Recommendation: Approve

Applicant: Albion Land

Proposal: Non-material amendment to 22/01632/REM - vary 12 of the approved plans and drawings listed in Conditions 1, 2 and 3. Amendments to Units 8 and 9 into a single unit, along with minor changes to Units 6, 7, and 8.

6.1. The proposal is considered to be non-material and the application is therefore recommended for approval.

Drawing Title:
UNIT 6 ELEVATIONS

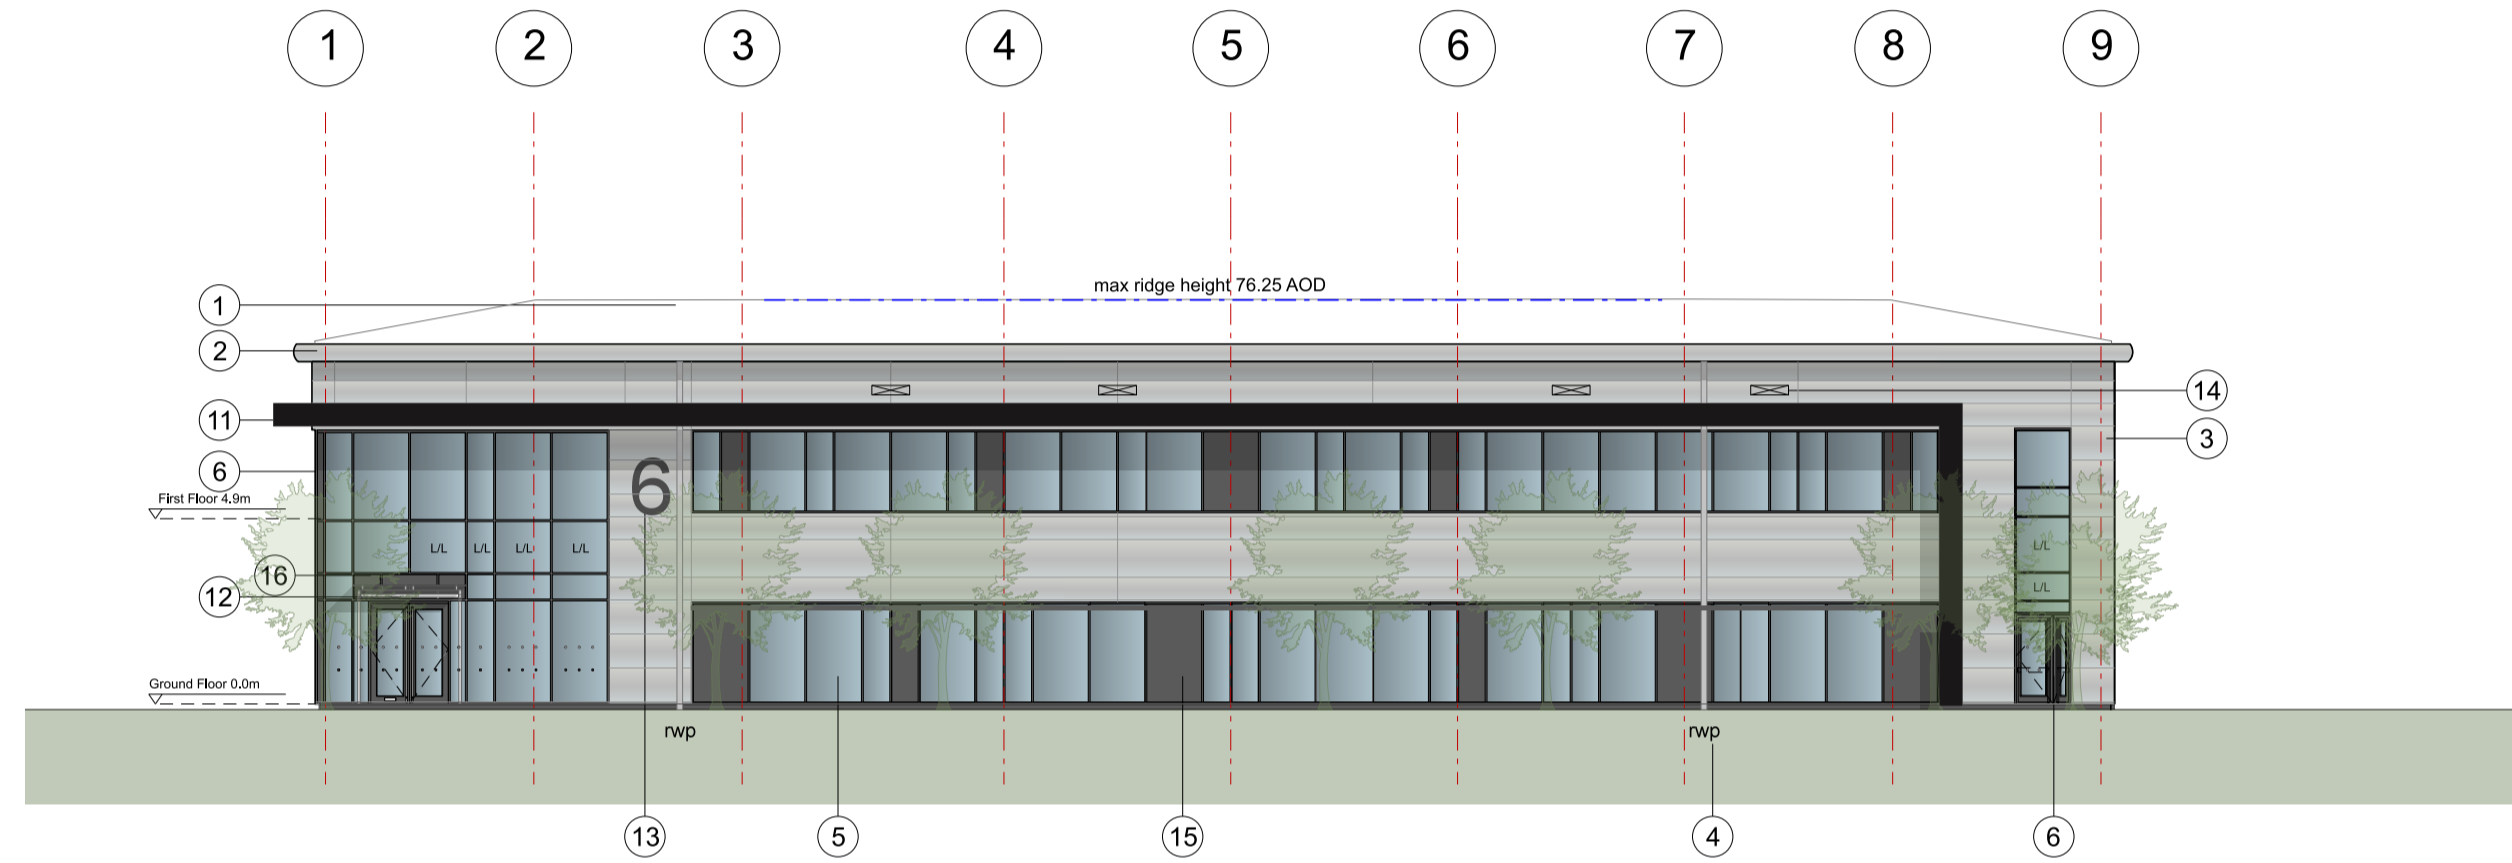
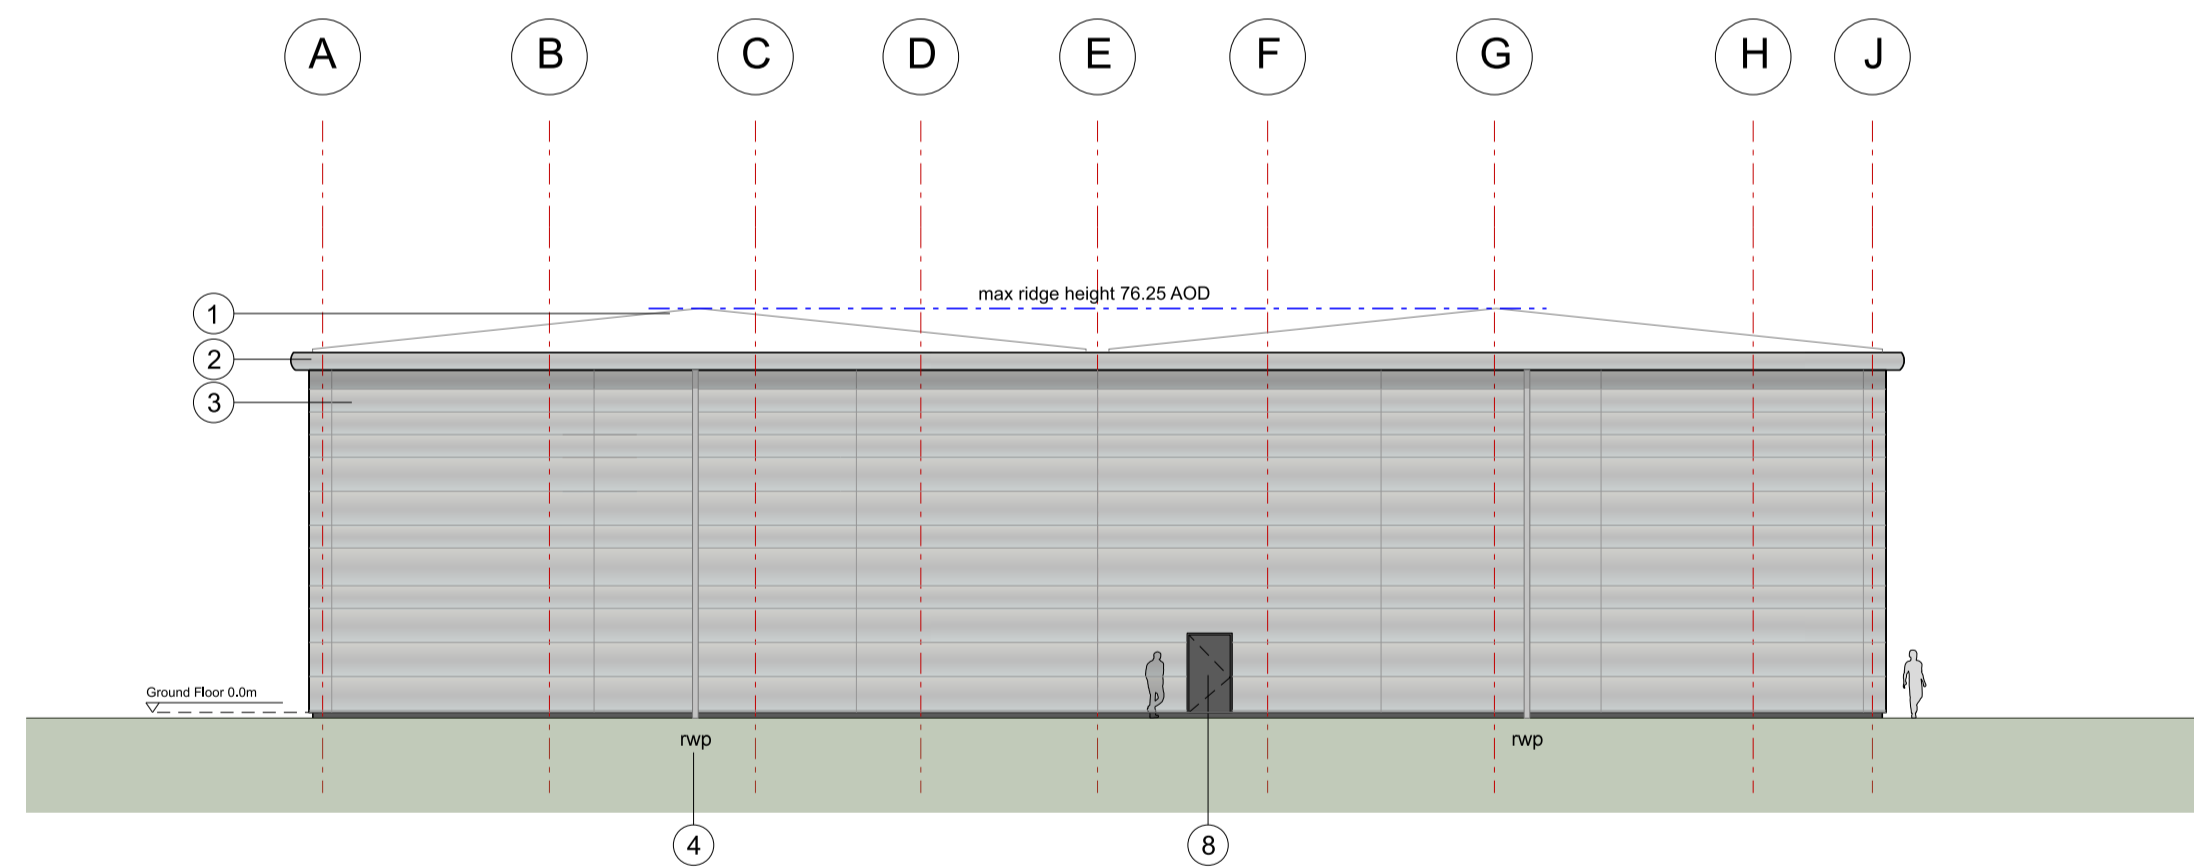
The applicant states that the changes are in response to the requirements of the secured occupier of the site. The window cassette arrangements have been updated following internal alterations and remain consistent with the scale and appearance of the building and buildings within the immediate vicinity. The downpipe positions have been updated to suit rainwater calculation. Materials remain unchanged. The changes are being sought by varying condition 1 to update the approved Floor Plans and Elevations for Units 6 and 7.
